MMC Employee Garage - site plan application submitted (#000207-2018)

From: **Jeremiah Bartlett** <jbartlett@portlandmaine.gov>
Date: Fri, Jun 22, 2018 at 12:22 PM
Subject: Re: MMC Employee Garage - site plan application submitted (#000207-2018)
To: Helen Donaldson <hcd@portlandmaine.gov>
Cc: Bruce Hyman <bhyman@portlandmaine.gov>, "Thomas.Errico@tylin.com" <thomas.errico@tylin.com>

VALLEY STREET & "D" STREET INTERSECTION
SCALE: 1"=10'

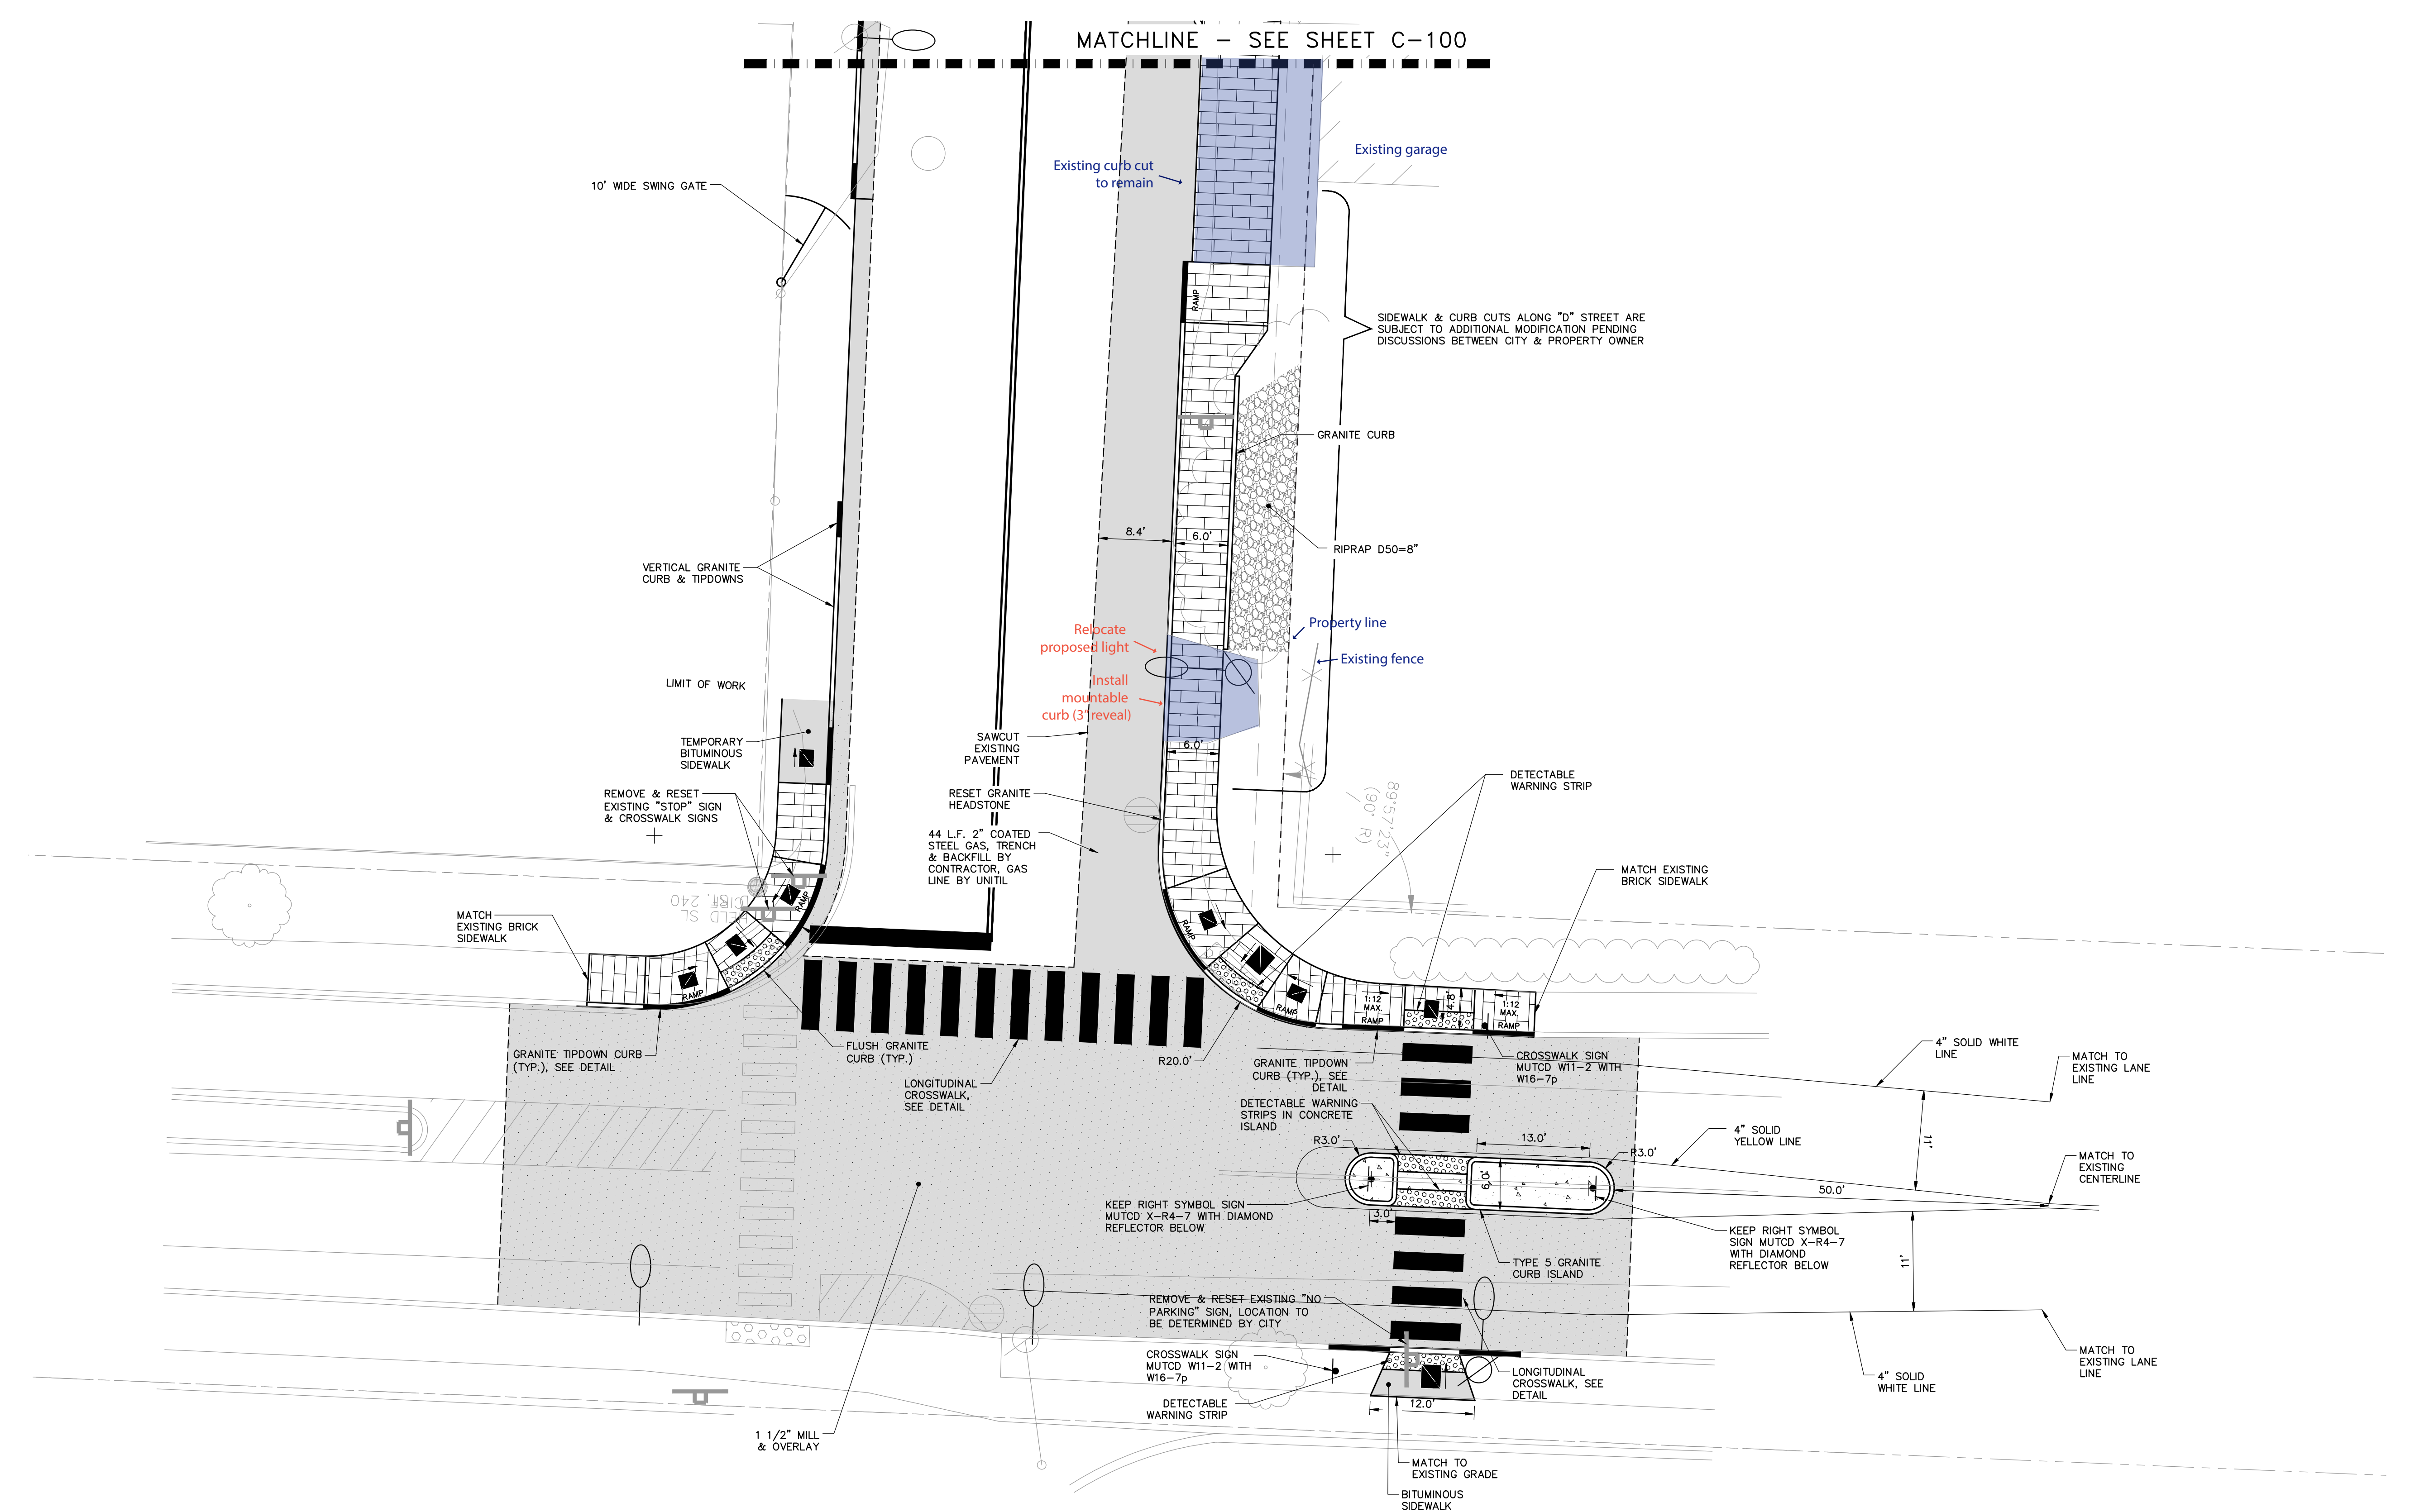
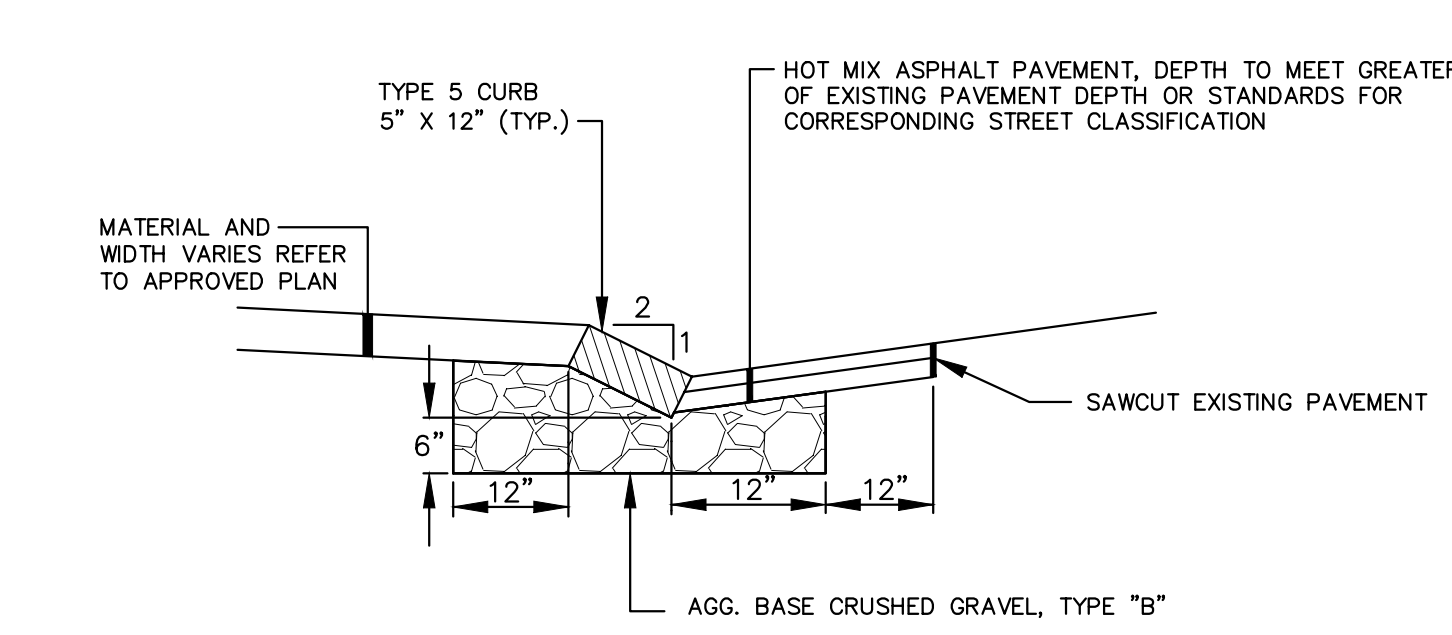
- 1.) The proposed sidewalk facility on the north side of D Street shall be placed as close to the right-of-way as possible, and provide the maximum width without reducing the street to less than 36 feet in width.
- 2.) To adequately define the street and replace on-street parking being eliminated by the proposed intersection reconfiguration with St. John Street and the primary garage entrance, curbing should be placed on the south side of D Street with existing driveways brought as close into conformance as possible. This would facilitate a future City sidewalk project in keeping with the original 1928 layout plans for D Street.
- 3.) The new crossing configuration of D Street, including islands and curb ramps shall consider either a payment up front to facilitate the changes on an imminent MaineDOT paving project of Valley Street.
